APPLICATION TO MAKE A NON-MATERIAL CHANGE
TO THE FOLLOWING DEVELOPMENT CONSENT ORDER:
The A14 Cambridge to Huntingdon Improvement Scheme Development
Consent Order 2016 (SI 2016 No 547) (as corrected by the A14
Cambridge to Huntingdon Improvement Scheme Development Consent
(Correction) Order 2017 (SI 2017/1121))

6. Book of Plans

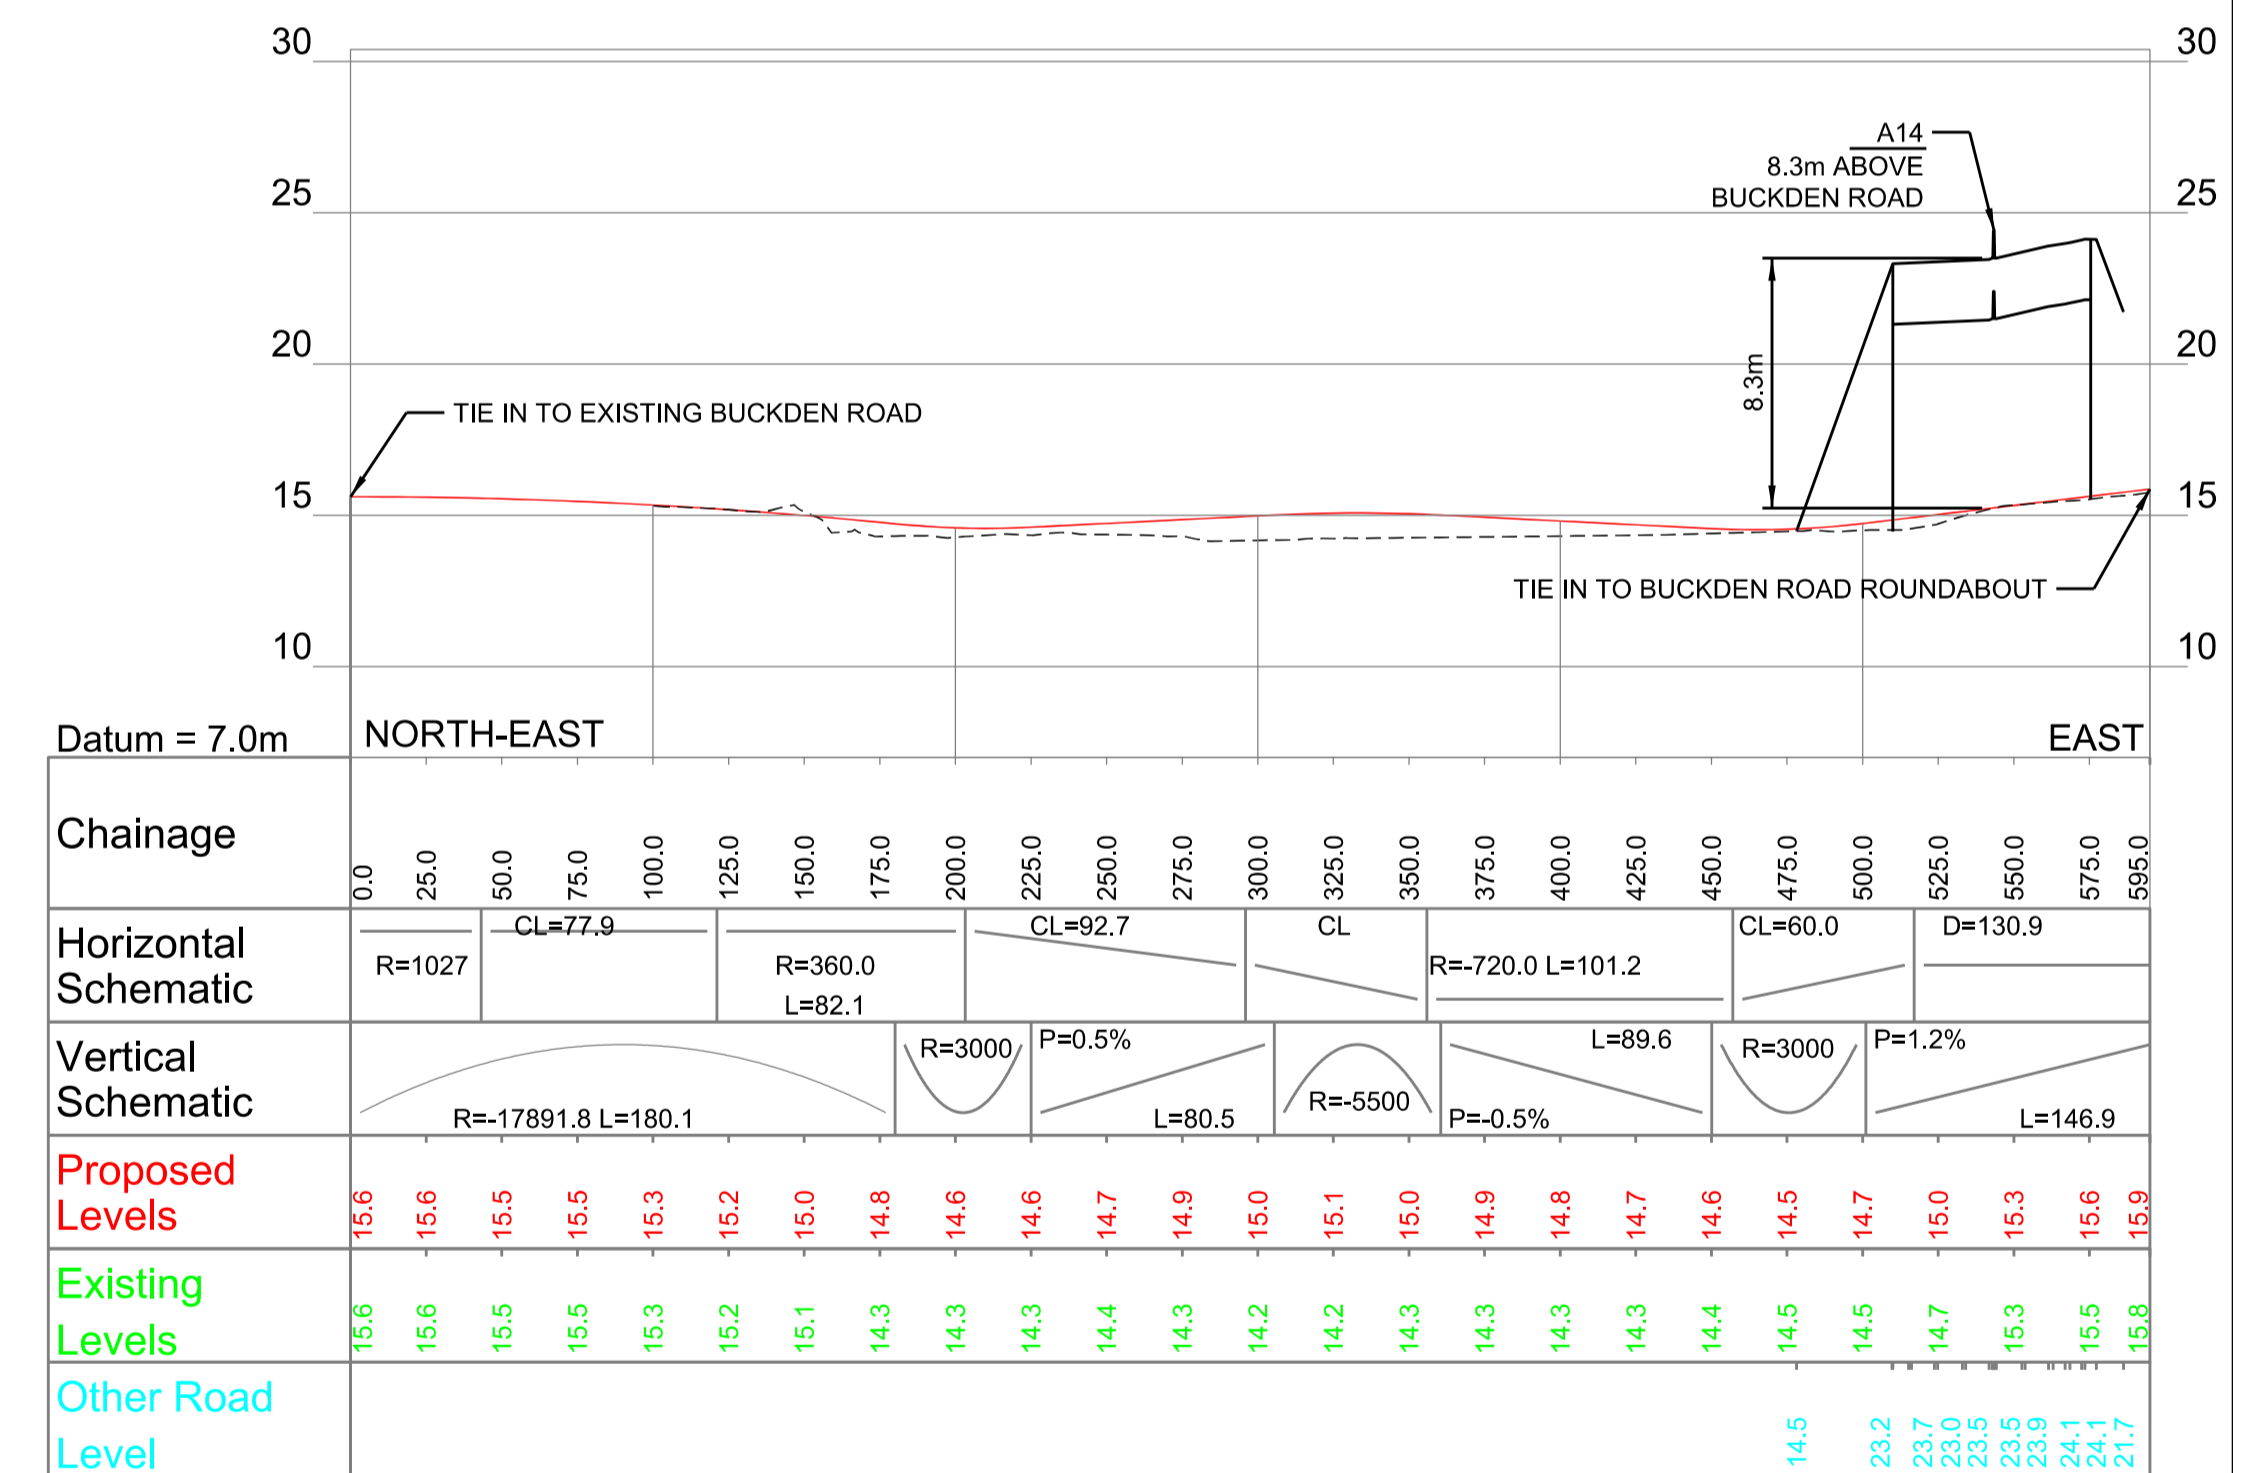
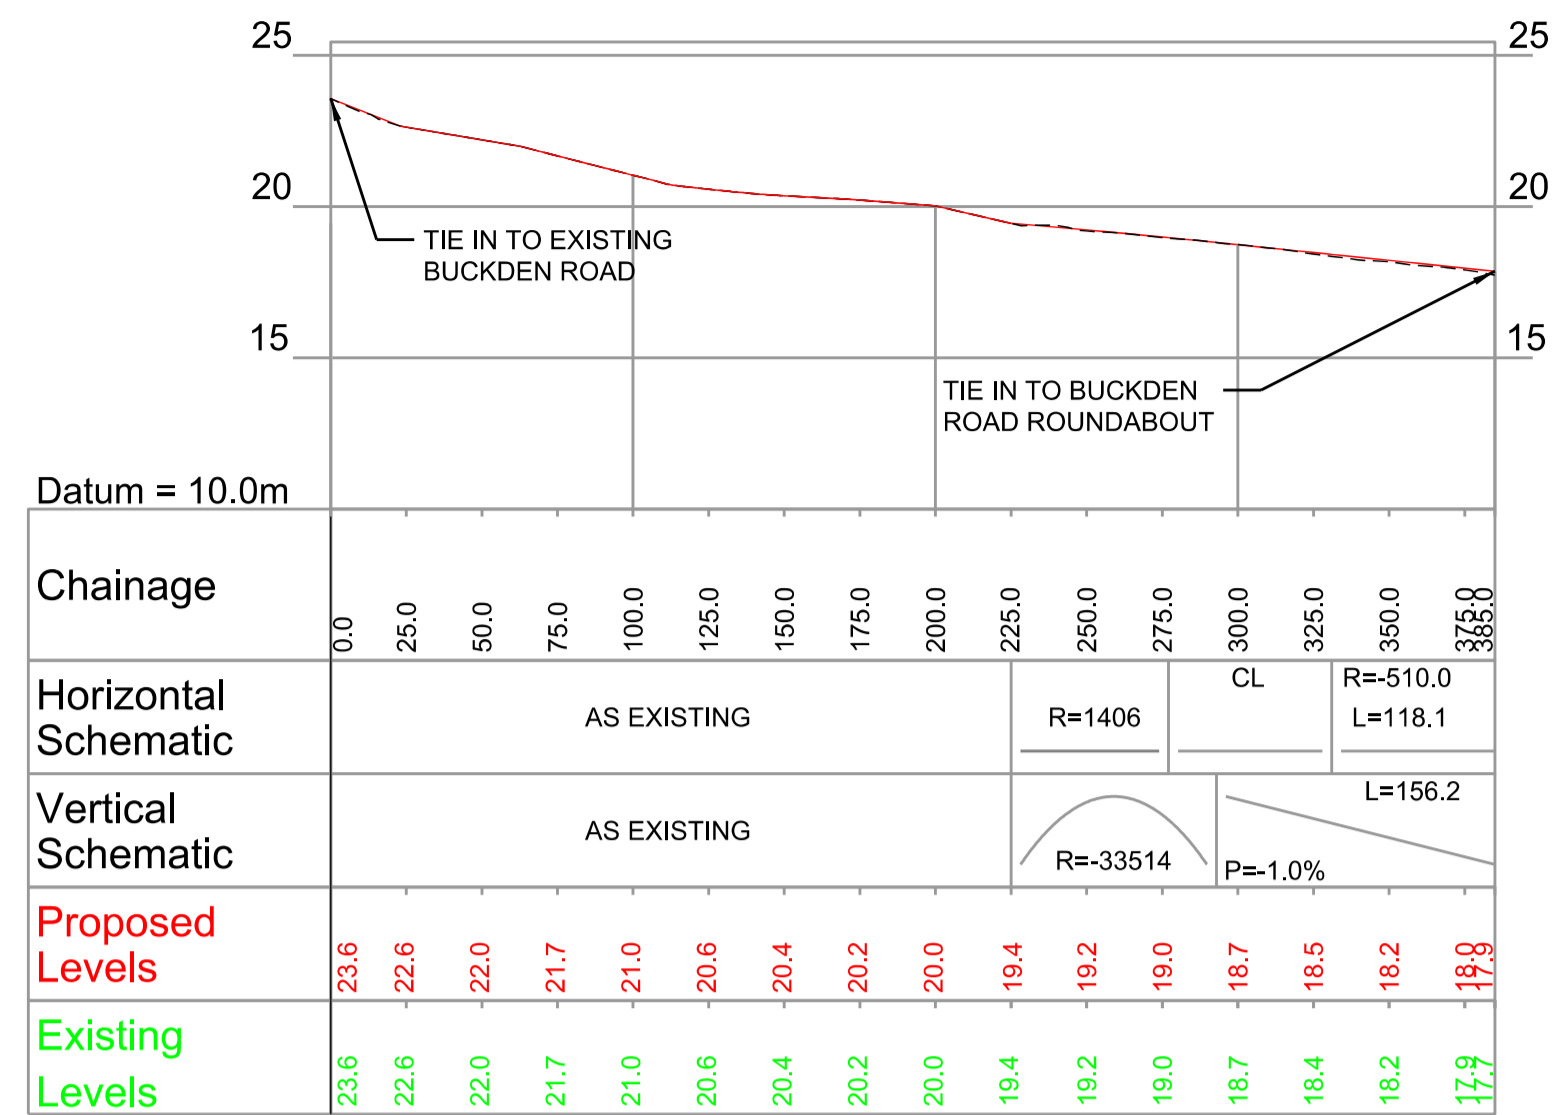
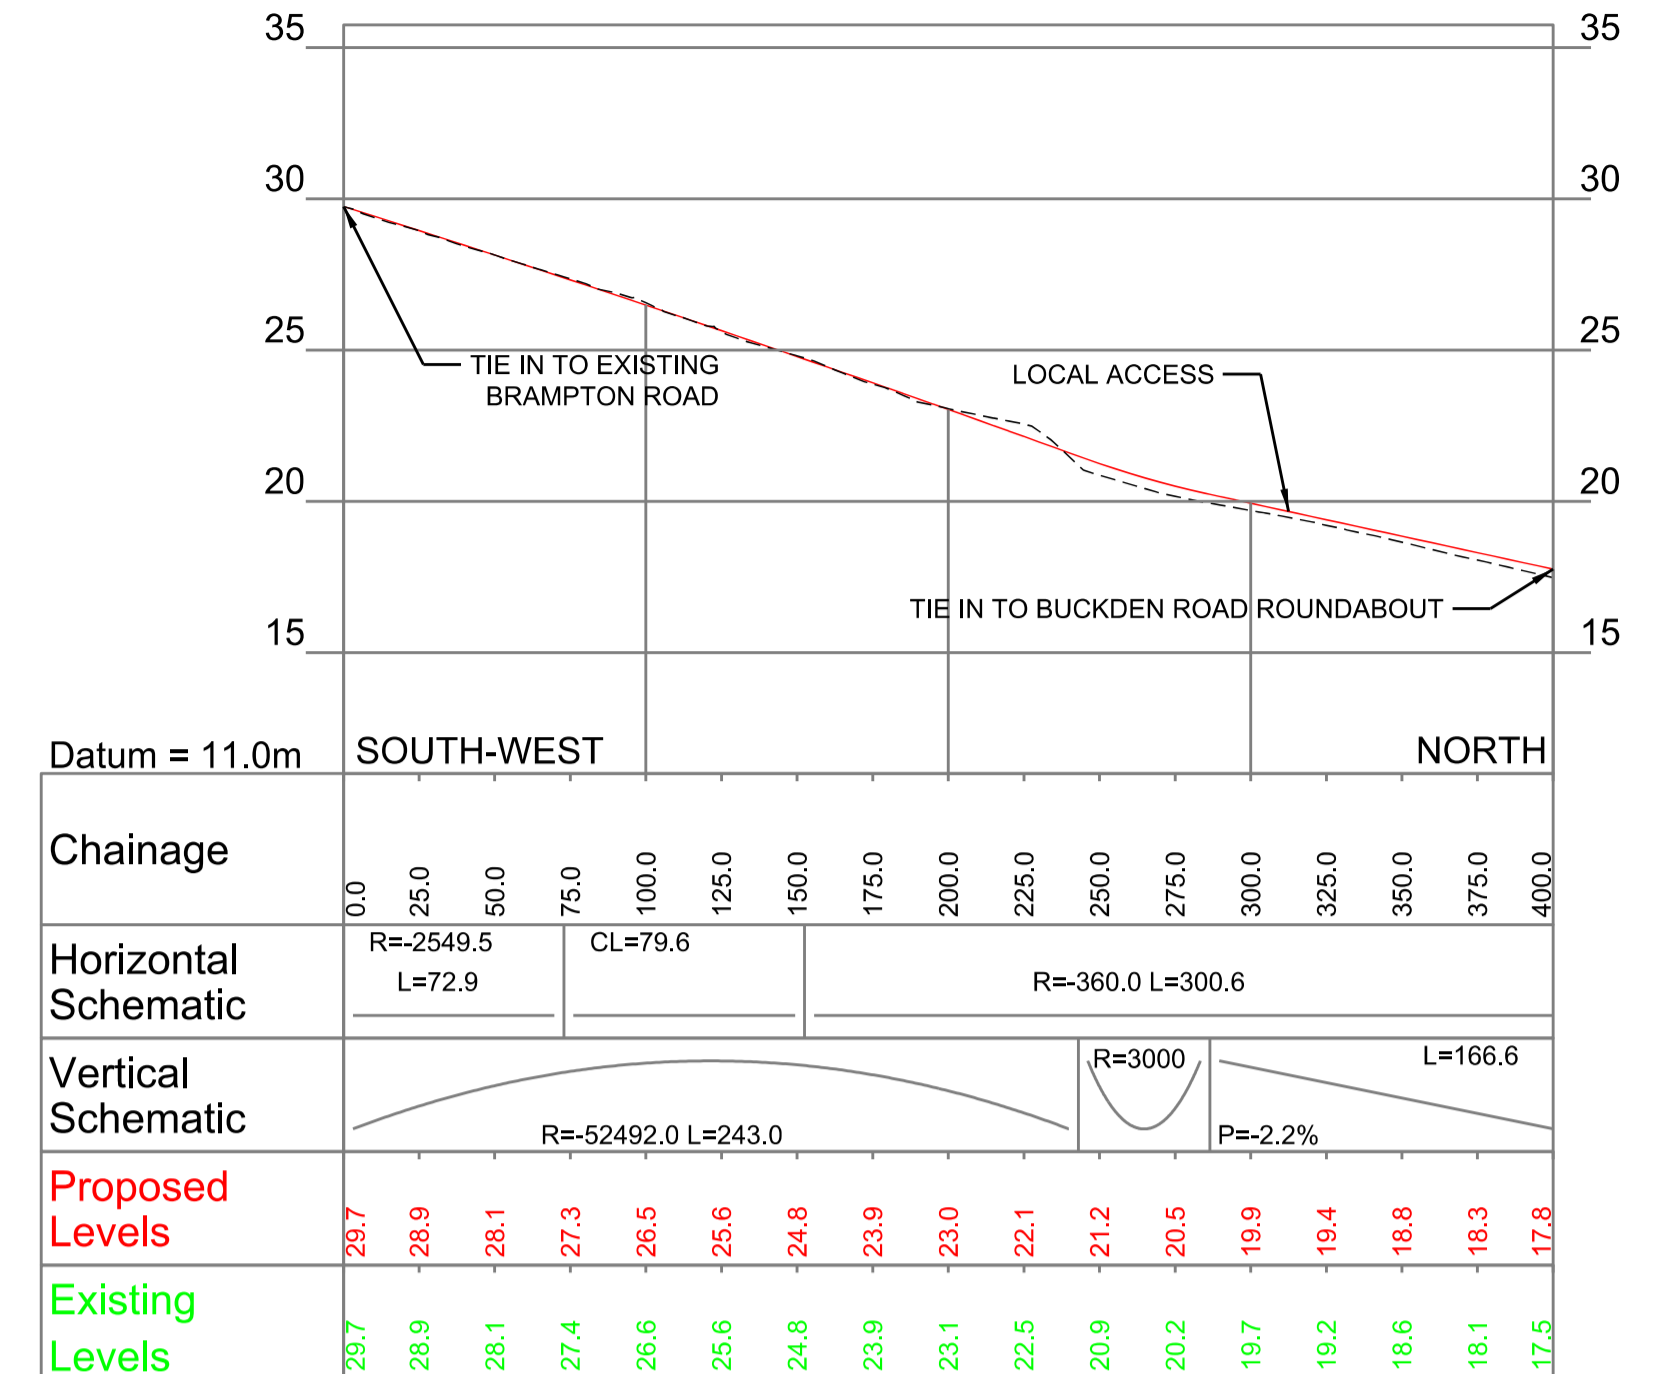
- (a) The extension of Work 9 at Buckden Road for an additional roundabout as described under General Arrangement Plans paragraph (b) above.

- (a) To show in section the extension of Work 9 as described in Works Plans paragraph (a) above.

Drawing title: **RIGHTS OF WAY & ACCESS PLANS REGULATIONS 5(2)(k) & 5(2)(c) SHEET 12 OF 28**

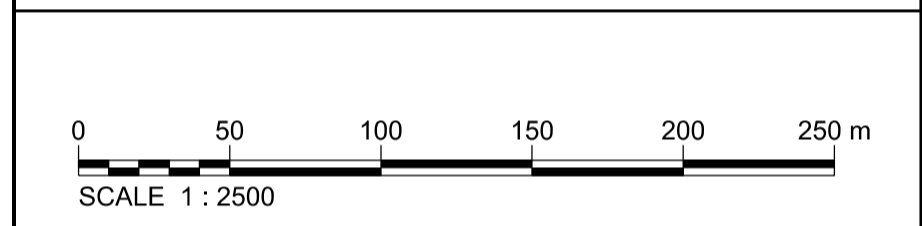
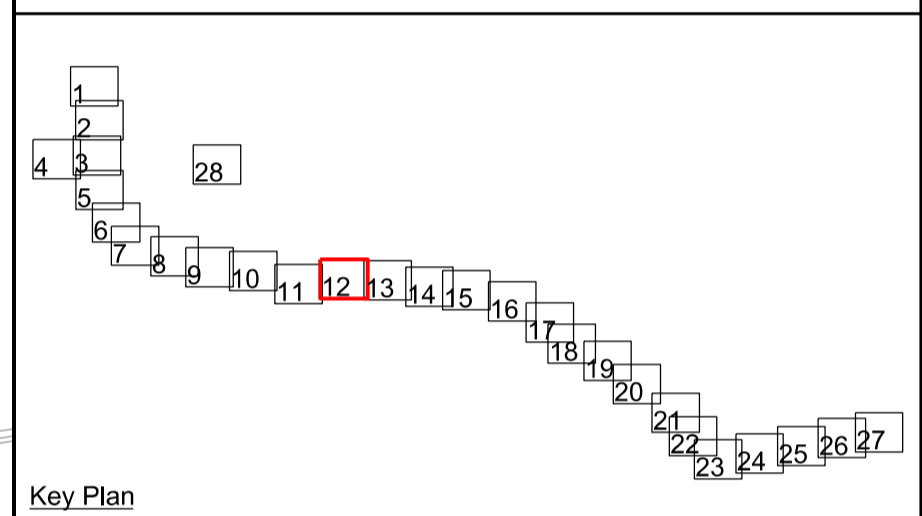
- (a) Identifying the mainline A14 and A1 as A14(M) and A1(M) Special Road.
- (b) The definition of the alternative bridleway route as described under General Arrangement Plans paragraph (a) above.
- (c) The removal of prohibitions on the mainline A14, as the Motorway Regulations include the prohibition of non-motorway traffic.

Drawing title: **TRAFFIC REGULATION MEASURES REGULATION 5(2)(o) SPEED LIMITS & PROHIBITIONS SHEET 12 OF 29**

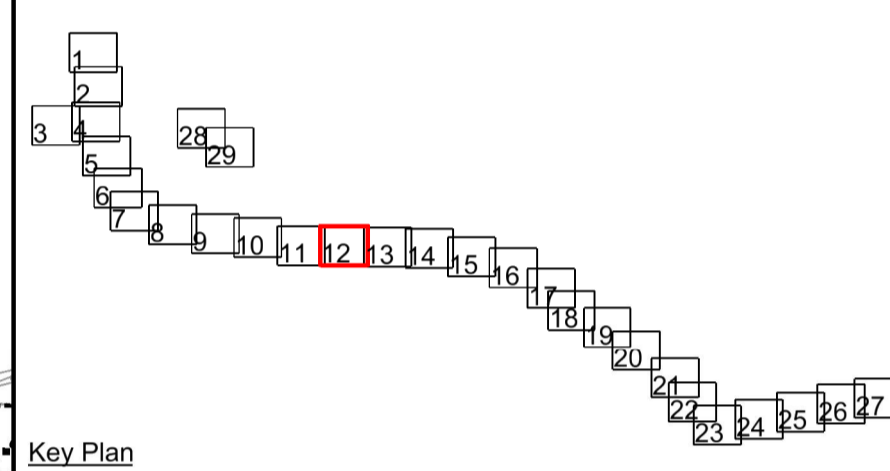
The amendment of the mainline A14(M) and A1(M) from fixed speed limits to variable mandatory speed limits.
